Permit Inspections Harnett County

Permit Number: BRES2211-0028

Description: **16x36 Workshop/garage**

Site Address: **3905 MCLEAN CHAPEL CHURCH RD**

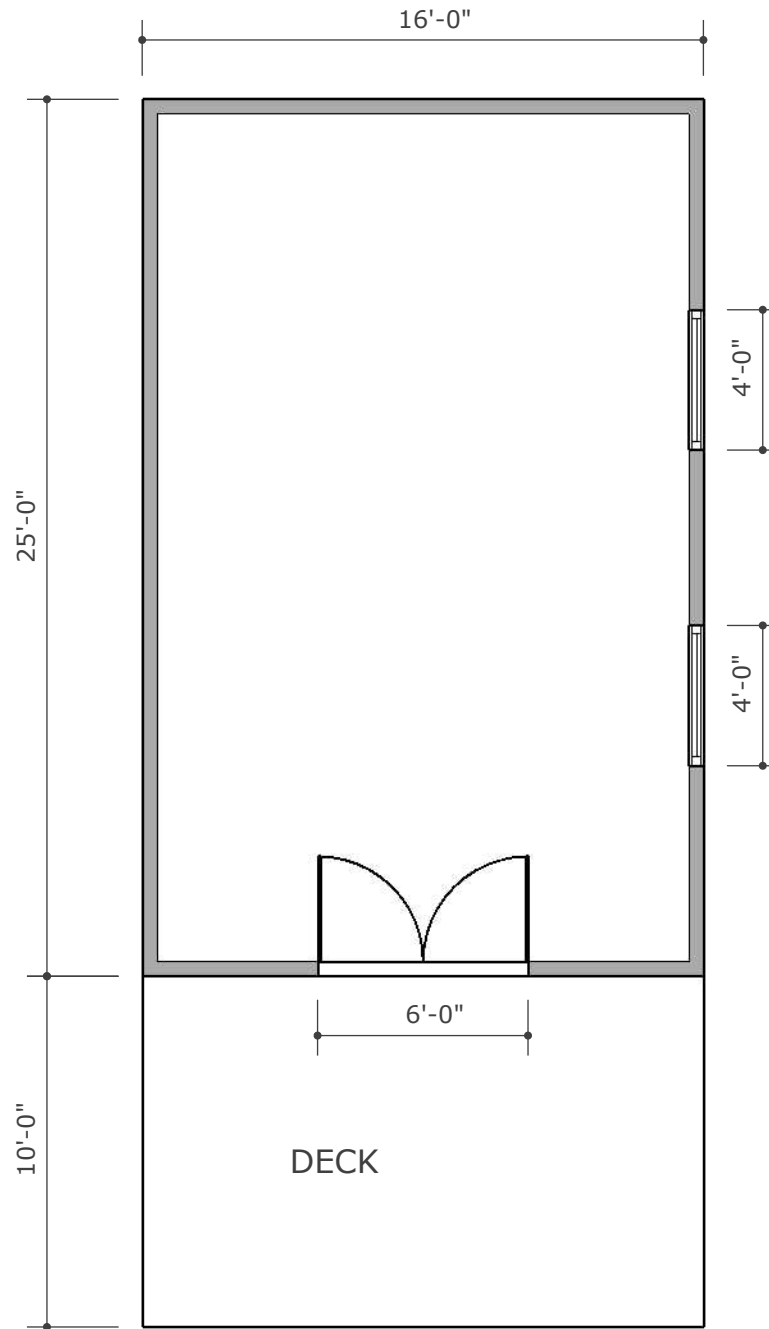
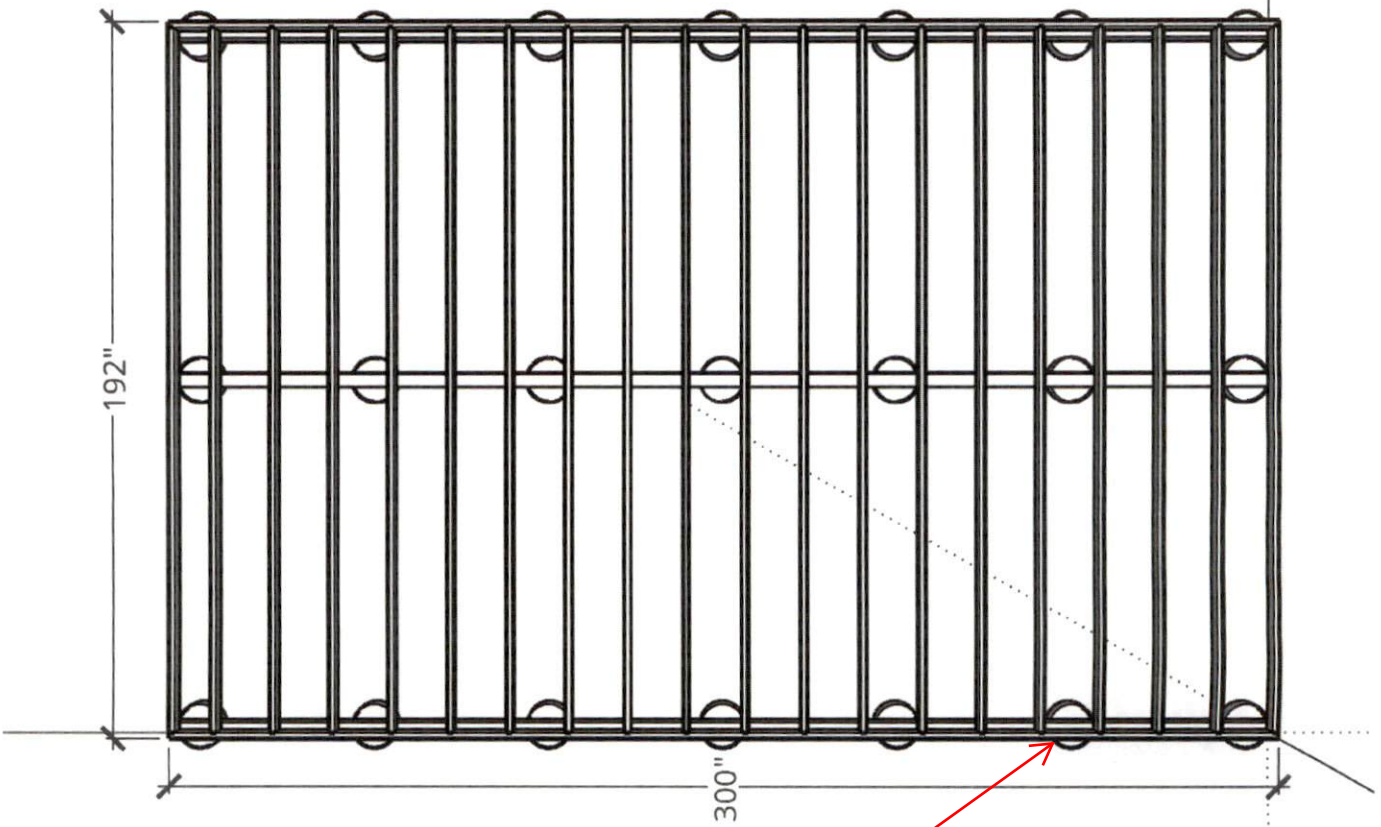
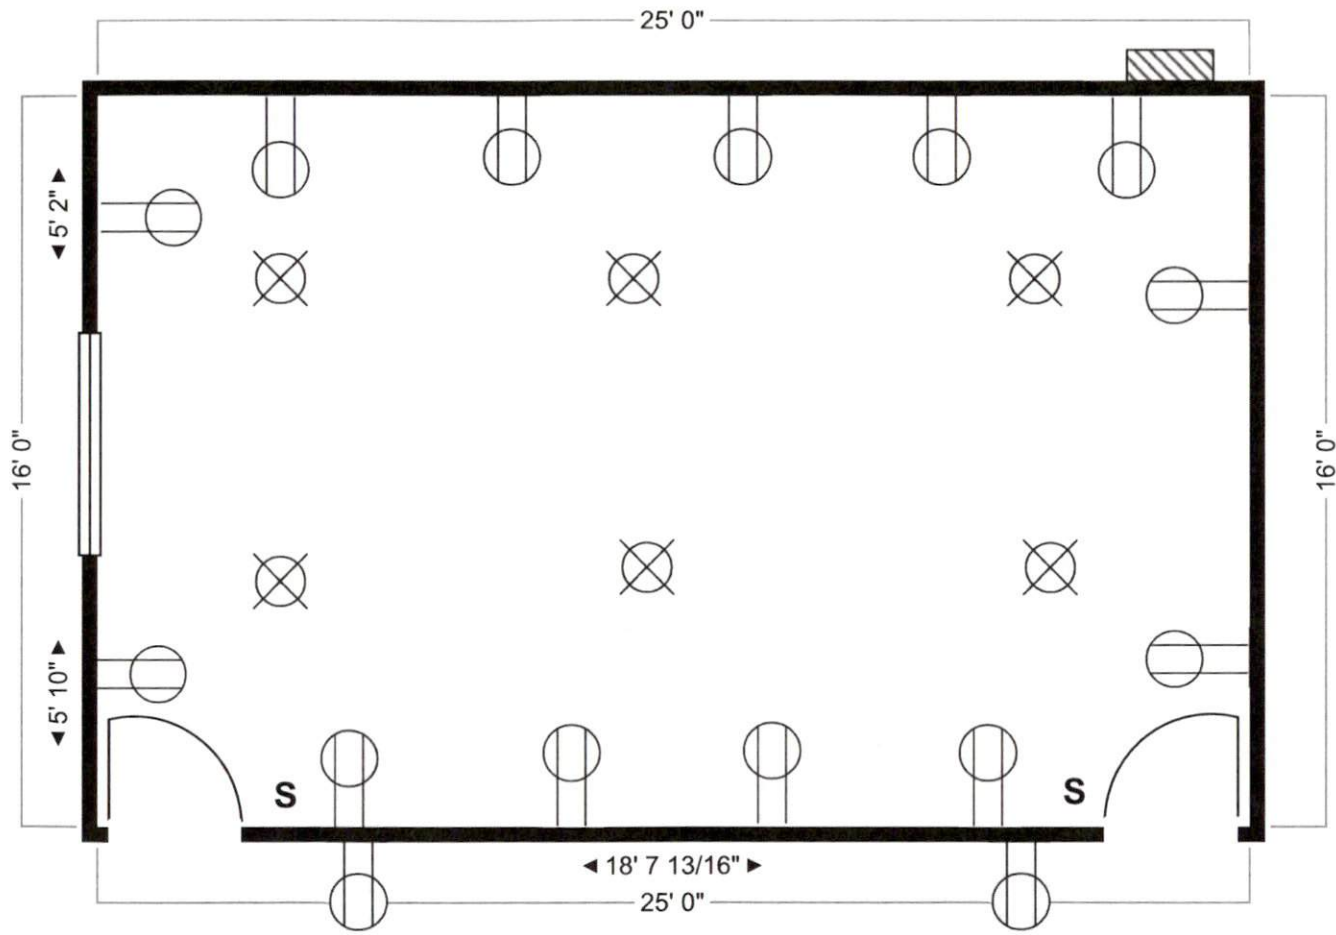
1/27/2023	1/27/2023	FOOTING	John B Kokoszka	DISAPPROVED	eTRAKiT Inspection Request
Notes: Multiple Locations have existing footing. Part of the piers and footings are in the middle of the leach field Vegetation needs to be removed Per plans footings need to be continuous. Need to clean out footings.						
	2/3/2023	2/3/2023	FOOTING	James T Hall	APPROVED	eTRAKiT Inspection Request
Notes: Passed By JK						
	2/3/2023	2/3/2023	OPEN FLOOR	James T Hall	APPROVED	
Notes:						
	3/2/2023	3/2/2023	ROUGH IN	James T Hall	DISAPPROVED	eTRAKiT Inspection Request
Notes: 2/28/2023 7:16 PM Li Lin Contact Name: Li Lin Site Address: 3905 MCLEAN CHAPEL CHURCH RD Phone: 6267575472 e-Mail: oztaxx@gmail.com 1. Need studs under all top plate breaks. 2. Nail girder beam on porch per code. 3. Missing king studs each sides of door & windows per code. 4. Strap all top plate joints That are 24" and less apart. 5. Make up all ground wires in boxes. 6. Fire caulk all holes through top plates per code.
